Application No: FG/14/25/PL

Site Address: 275 Goring Way Ferring BN12 5BY

Description of works: Partial removal of rear extension of 275 Goring Way and erection of 1 No. self-build chalet bungalow in garden of 275 Goring Way with associated landscaping and parking. This application is in CIL zone 4 and is CIL liable.

Thank you for your internet representation made on 20th February 2025 which has been recorded as an objection with the comments as follows:

APPENDIX 5. TREE PROTECTION PLAN (EXTRACT)

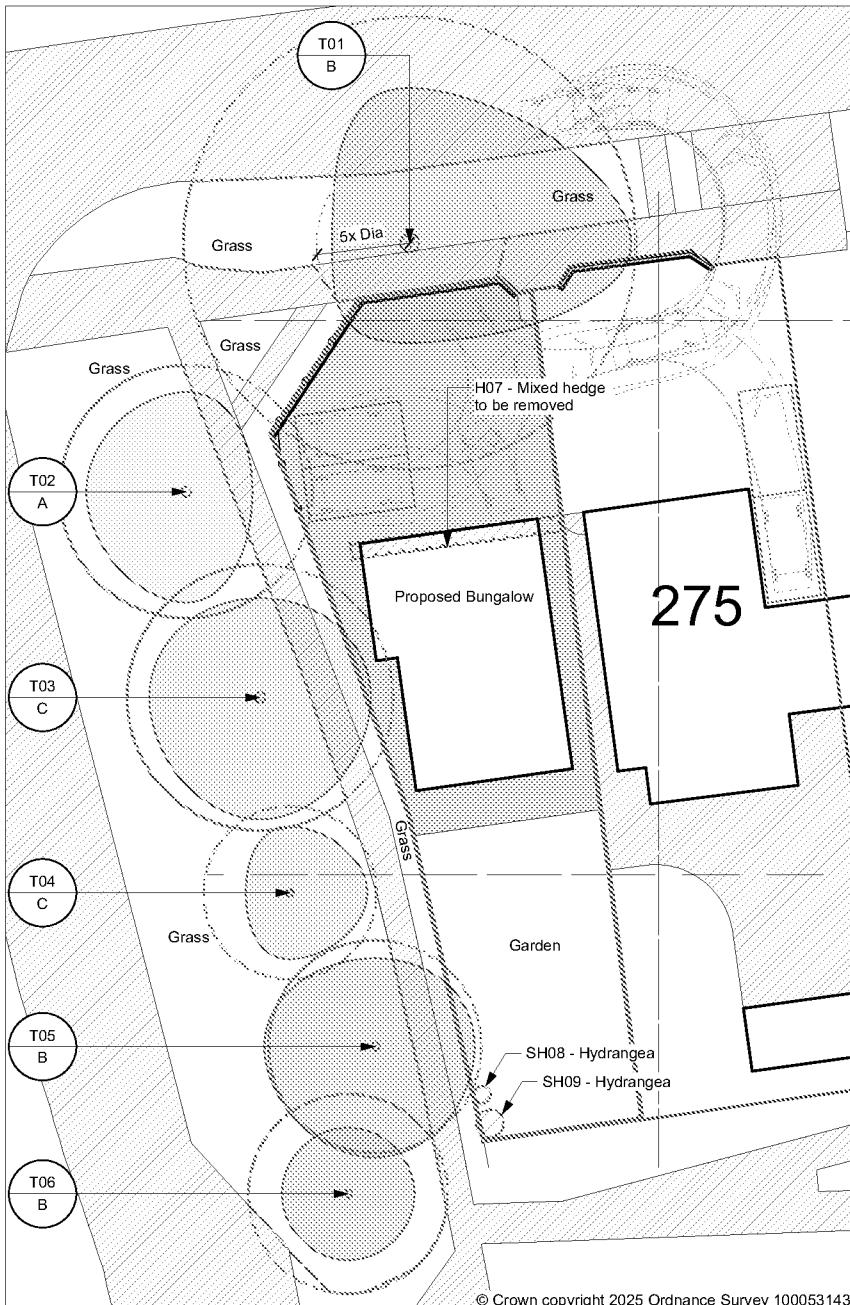
It is noted that the Arboriculture Survey recommends excavation under supervision to prevent root damage.
